Our ref: DOC20/130830-8

Your ref: SSD-10159

**Northside Private Hospital, West Gosford (SSD-10159) – Review of Environmental Impact Statement**

**Date: 24 March 2020**

Figure 5.1: Proposed Stormwater Drainage Layout

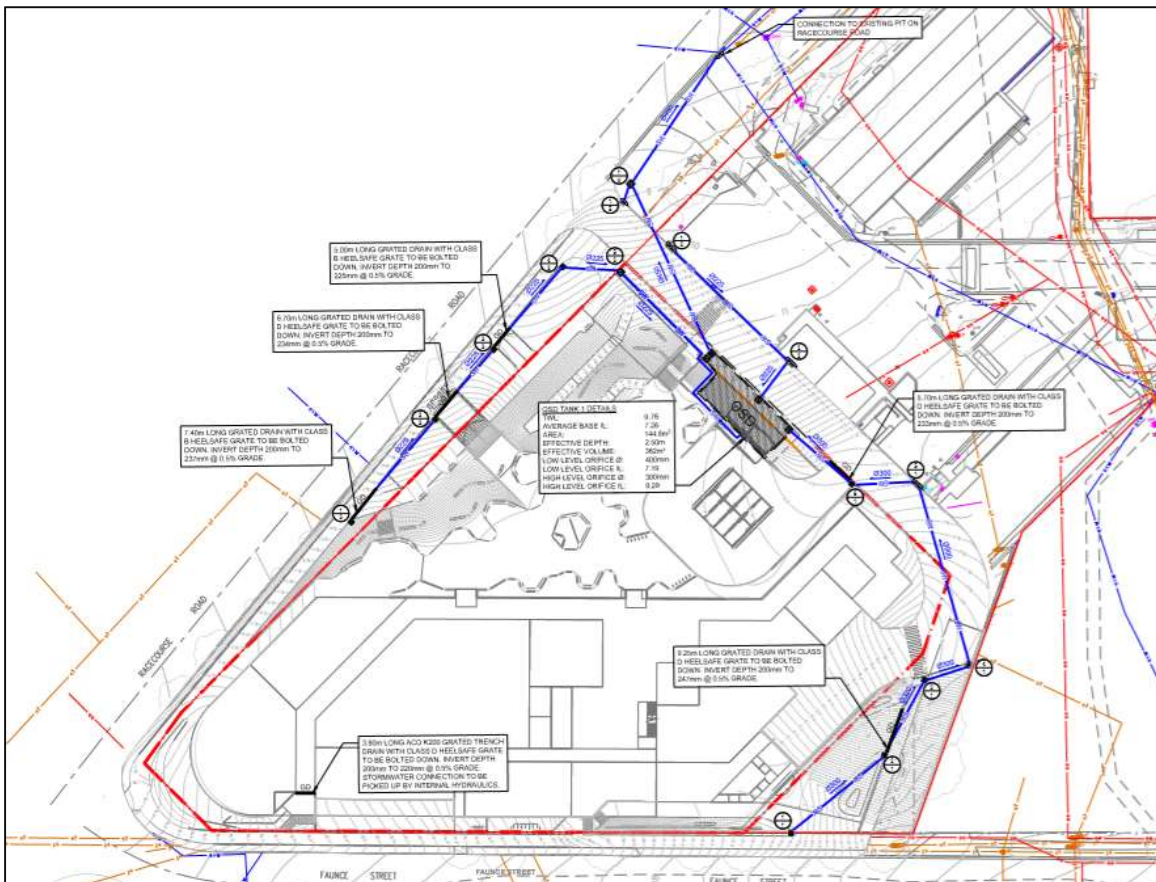
The stormwater management plan proposes to reduce post development stormwater flow rates from the site to predevelopment levels in accordance with Central Coast Councils requirements. This is proposed to be achieved by piping all stormwater via a large on-site detention tank towards the Racecourse Road boundary of the site and piping the outflow from the tank to Council's stormwater inlet pit in the kerb of Racecourse road. Figure 66 of the EIS shows existing pits and pipes are only 375mm diameter and 450mm diameter in the Council roadway.

The proposed onsite detention discharges via a 450mm diameter pipe. The receiving system does not have the capacity to receive this concentrated flow. Upgrading of Council's existing drainage system will be required if this arrangement is used.

Stormwater quality management after construction is proposed to be managed through the use of proprietary treatment cells that will be located in the base of the on-site detention tank. It is not clear if the placement of these cells in the bottom of the tank is feasible as the inserts may not perform properly in a fully submerged environment as they are designed to work in a flow-through environment and generally best placed offline so they receive low flows only.

Resuspension or undertreatment of nutrients is likely. The location at the base of the tank also poses a safety risk to staff servicing them.

The proponent should investigate the capacity of Council's existing stormwater system to receive discharge from the on-site detention system. Alternatively, use of several, smaller on-site detention devices may result in the proposed system being more compatible with the receiving drainage system, and be useful for mitigating overland flow of larger storm events.

The proponent should provide more details of the suitability of the proposed operational water quality treatment method, including details of whether the proposed treatment cells will operate properly when fully inundated and details of the cells servicing requirements.

The proponent should consider alternative water quality treatment options, including water sensitive urban design features such as bioretention ponds.

Figure 7.5: Sediment Basin Outlet Pipe Detail

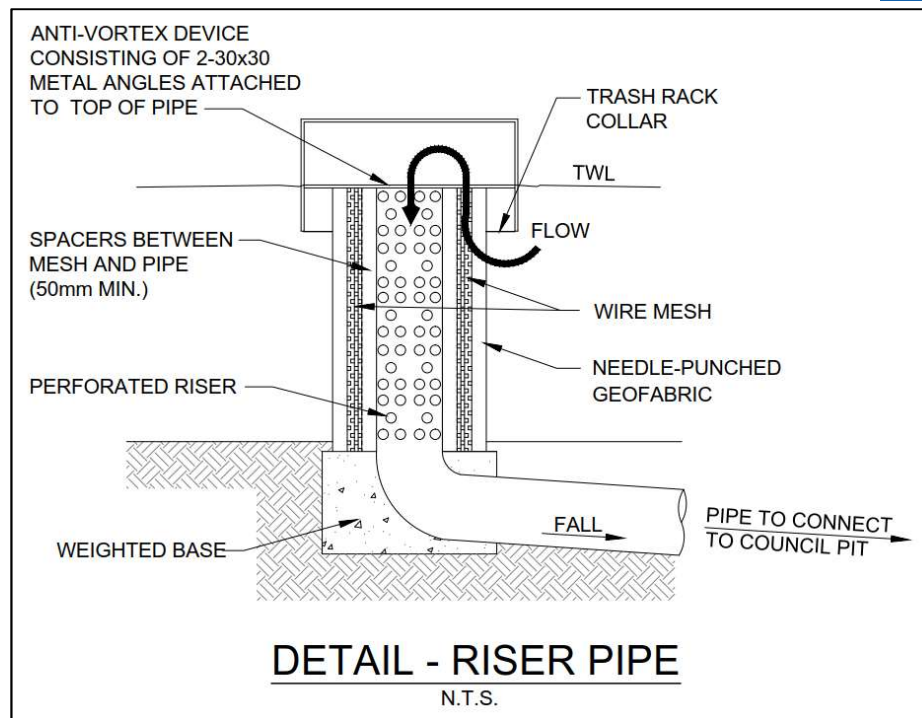
Sediment basin calculations are generic and do not consider the method of construction. The stormwater report states that existing reeds will be removed as part of construction, although there do not appear to be any existing basins or reeds on site. The concept civil engineering plans show use of the basement lift well as a sediment basin.

The stormwater management and construction environmental management plans should be revised to reflect site specific conditions, construction methods including bulk excavation and rock breaking, and other relevant environmental impacts identified for the project.
